**CITY OF ALBUQUERQUE  
PLANNING DEPARTMENT  
February 18, 2015  
DRB Comments**

**PROJECT # 1003275**

**APPLICATION # 15-70051/ 70052**

**RE: El Rancho Atrisco Phase 3**

SITE PLAN FOR SUBDIVISION

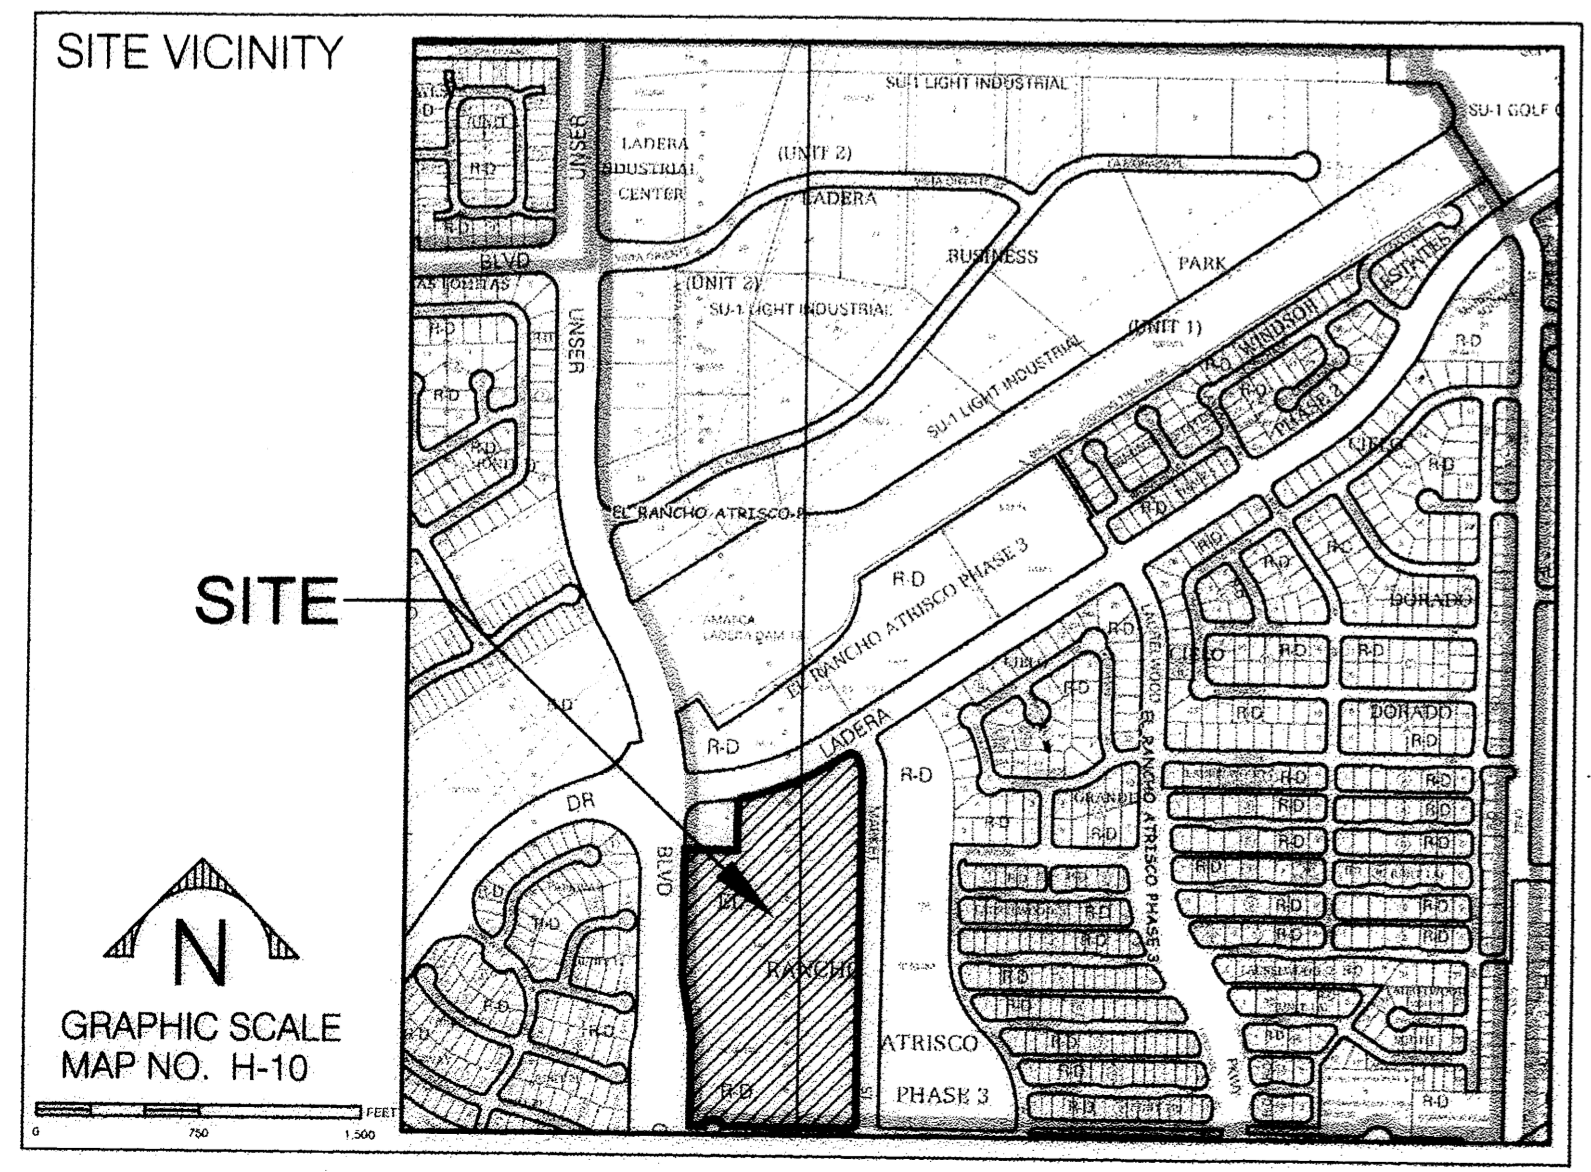
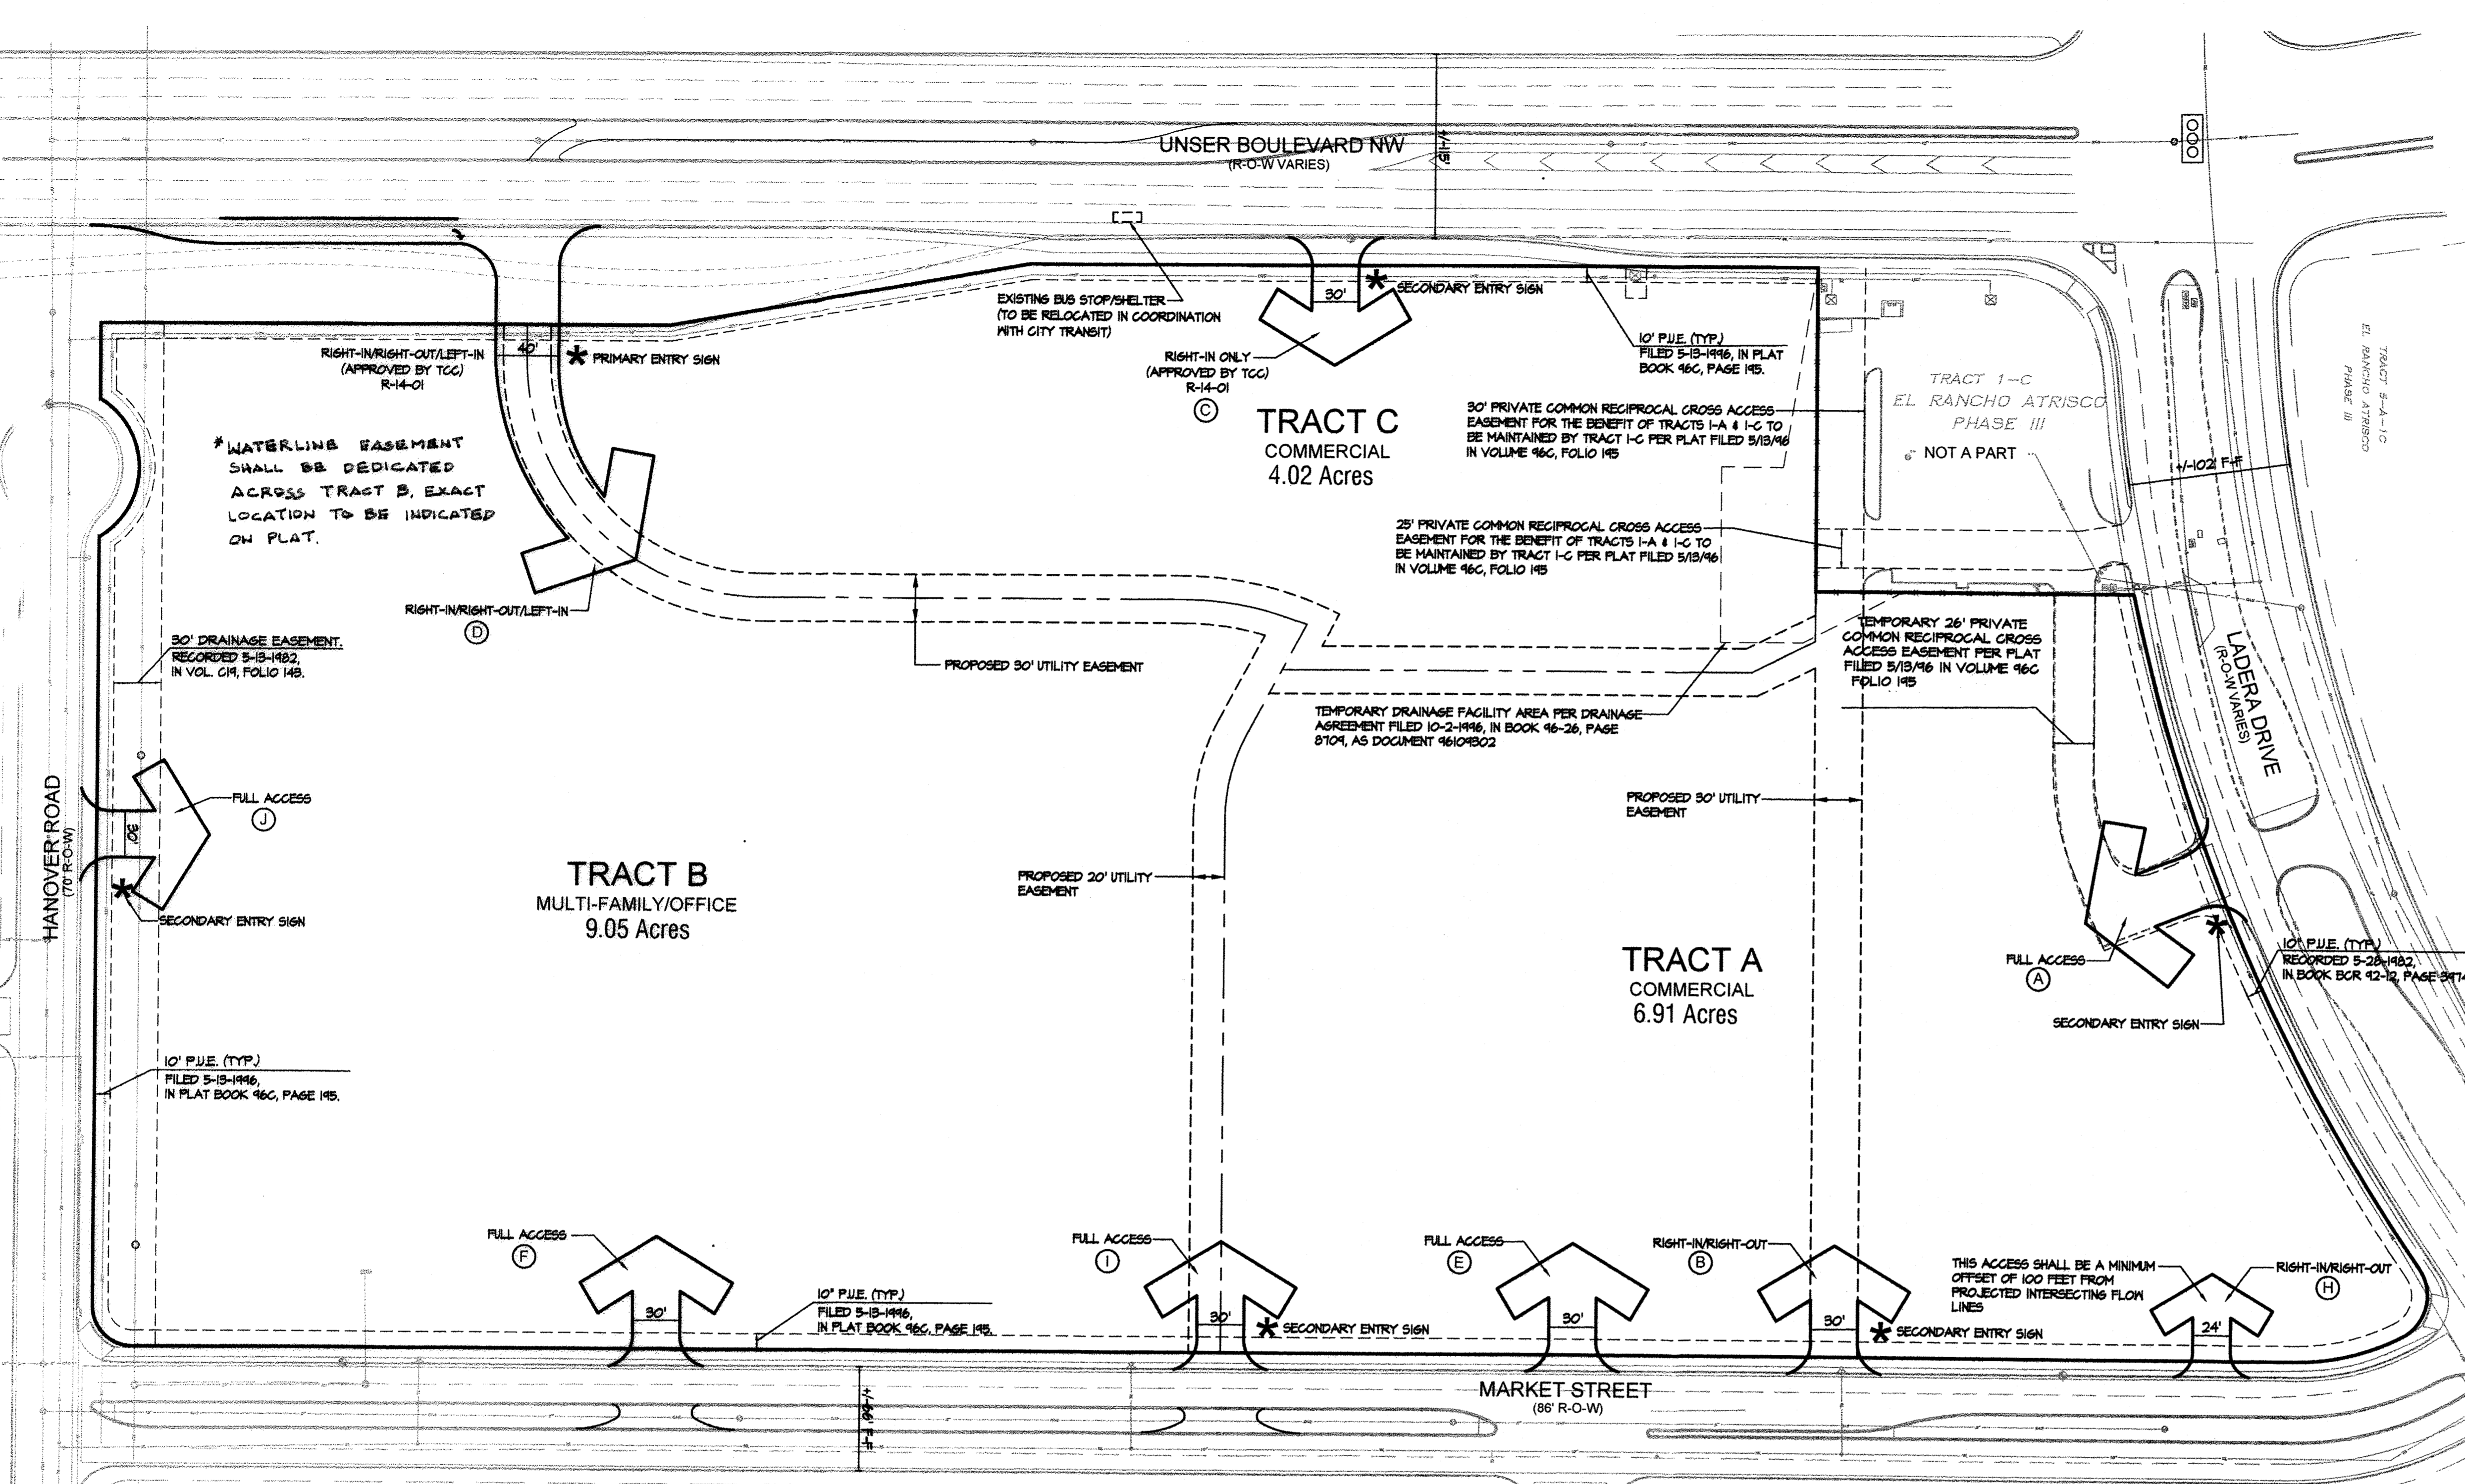
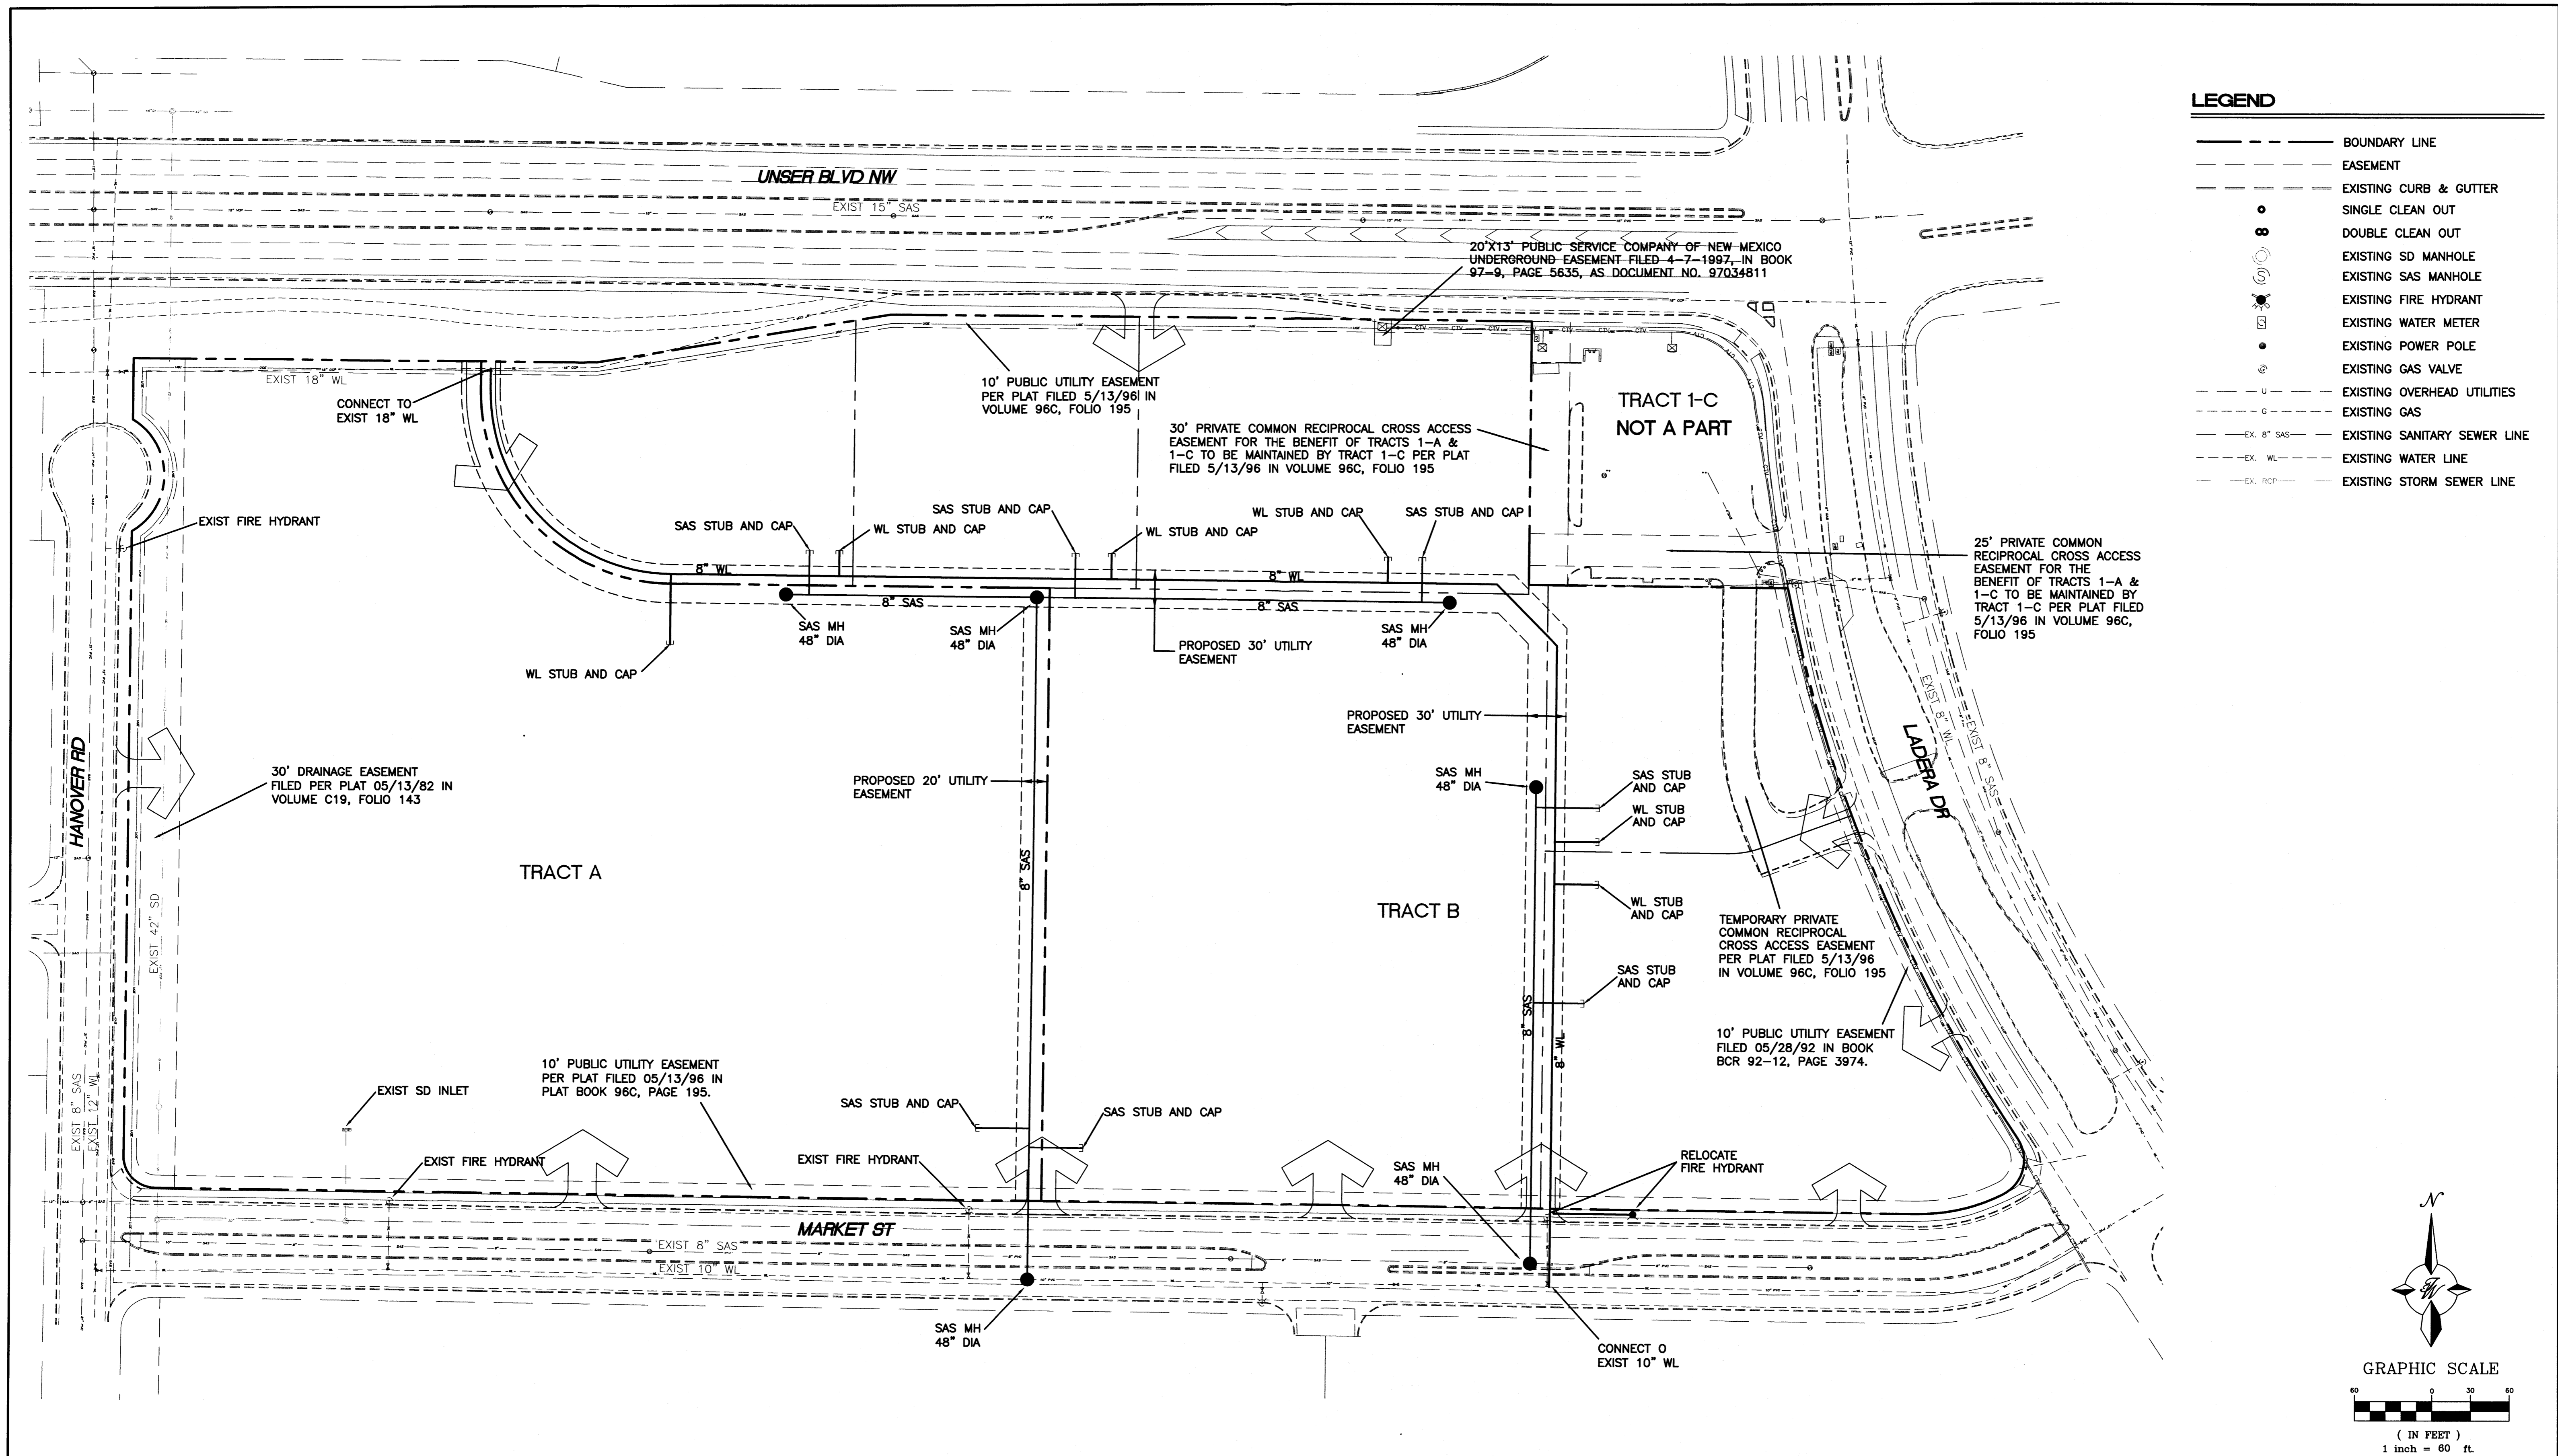
I have reviewed the Site Development Plan for Subdivision for Project #1003275/13EPC-40148 and have the following comments:

1. The wording of Condition 4 must be on the Site Development Plan page 1 under the Note about the cross access easement as follows "Future Development on the site will require EPC review of a Site Development for Building Permit(s)"
2. The wording of Condition 8 shall be added as a note on the cover sheet under PEDESTRAIN AND VEHICULAR INGRESS AND EGRESS. Add as the last sentence to that paragraph.
3. The project # and case number's must be filled in on the Signature Block.
